Consultee Comments for Planning Application

Application Number: 1/0326/2021/FUL

Address: Building At Aishleigh Shebbear EX21 5SN

Proposal: Replacement stables

DRAWING TITLE
REPLACEMENT STABLES
Location + Site Plans

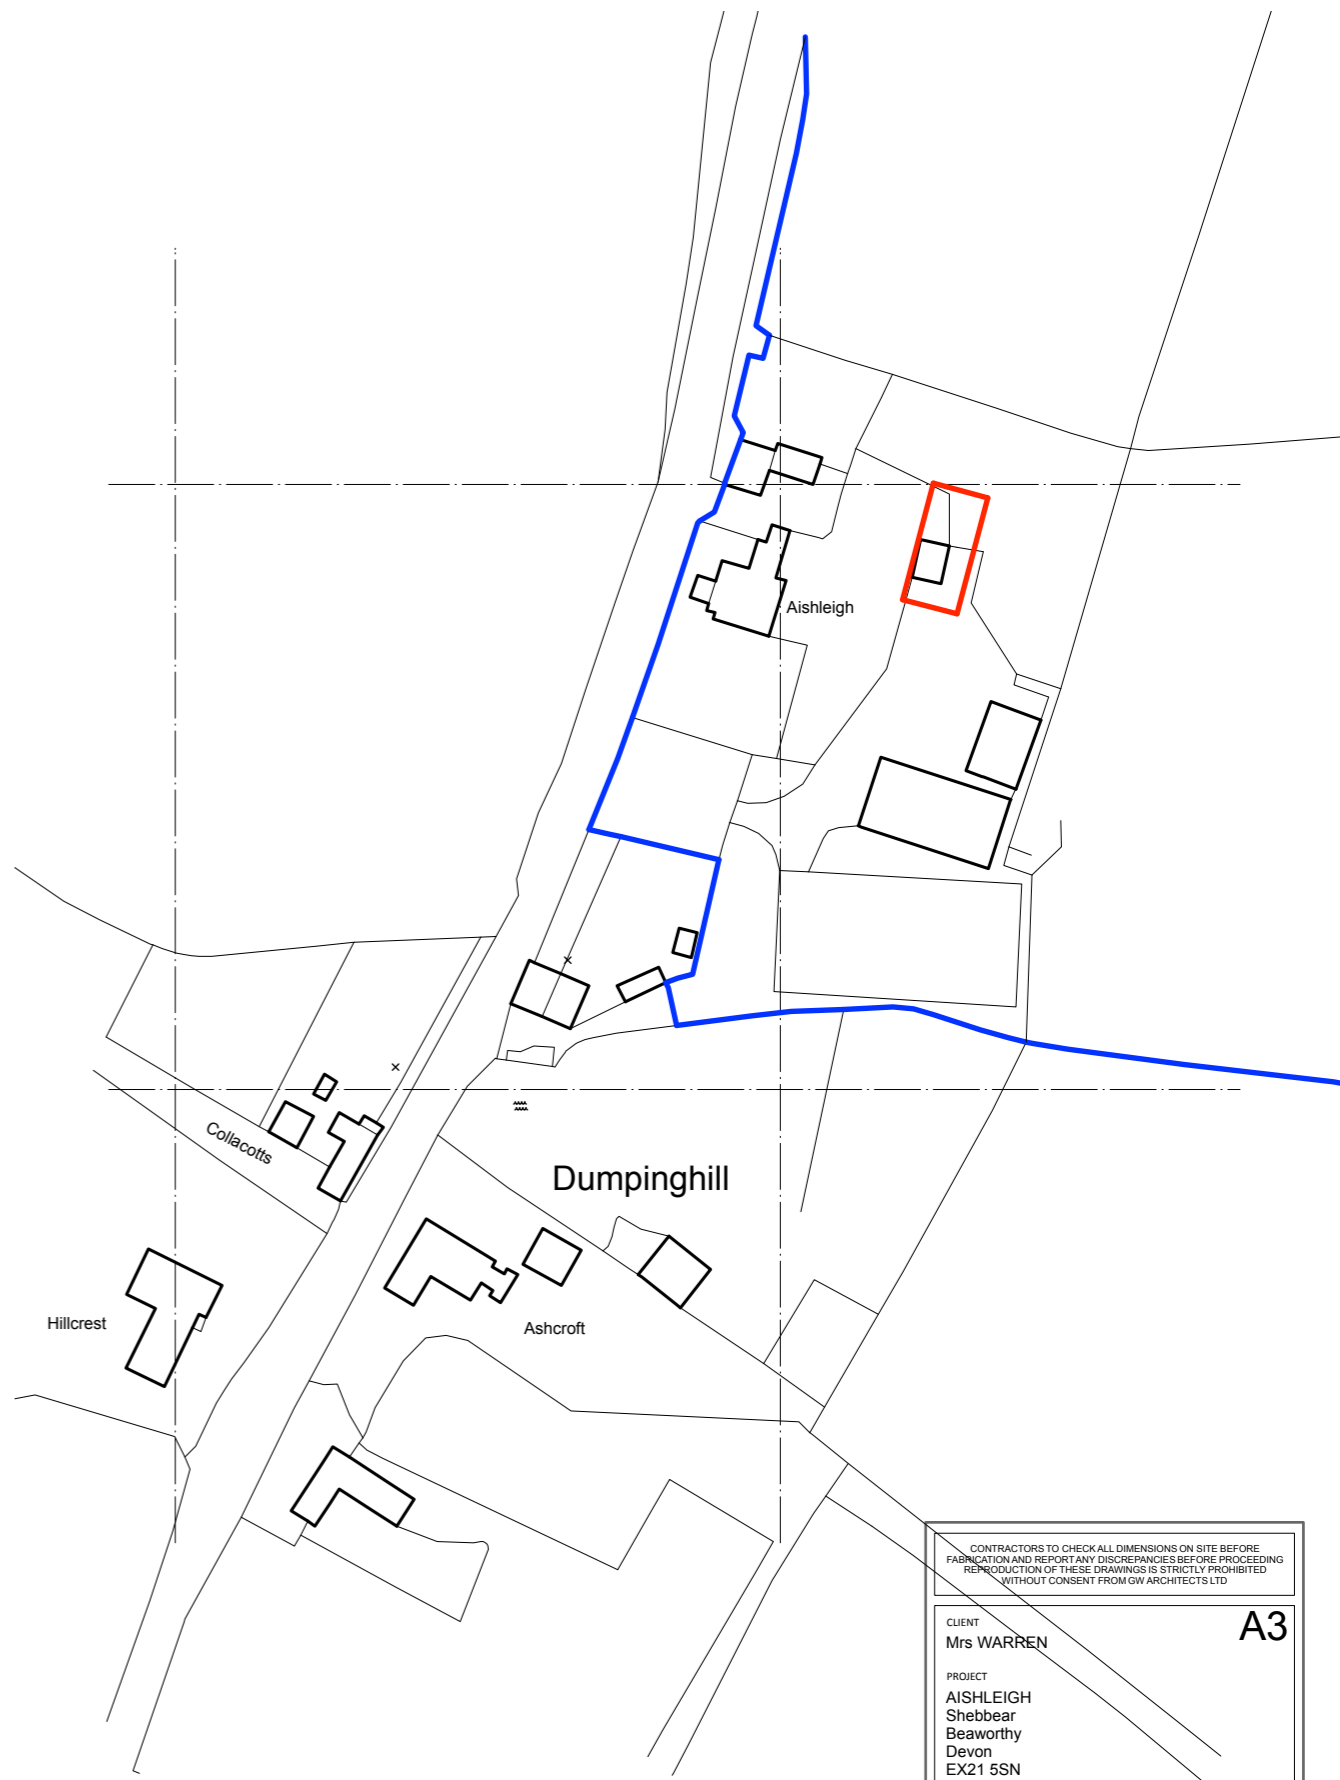
The location of manure waste storage is not apparent from the information provided. The accumulation of manure waste, associated with equine, has the potential to cause detriment to residential amenity from the odour and fly nuisance associated with manure. Having regard for neighbouring dwellings, it is essential that any manure waste storage is located at such a distance to prevent or minimise any adverse impact. Should planning consent be granted, the Environmental Protection Team recommends the imposition of a condition stipulating a minimum distance of 50 metres between any manure waste storage and the boundary of third party residential properties.
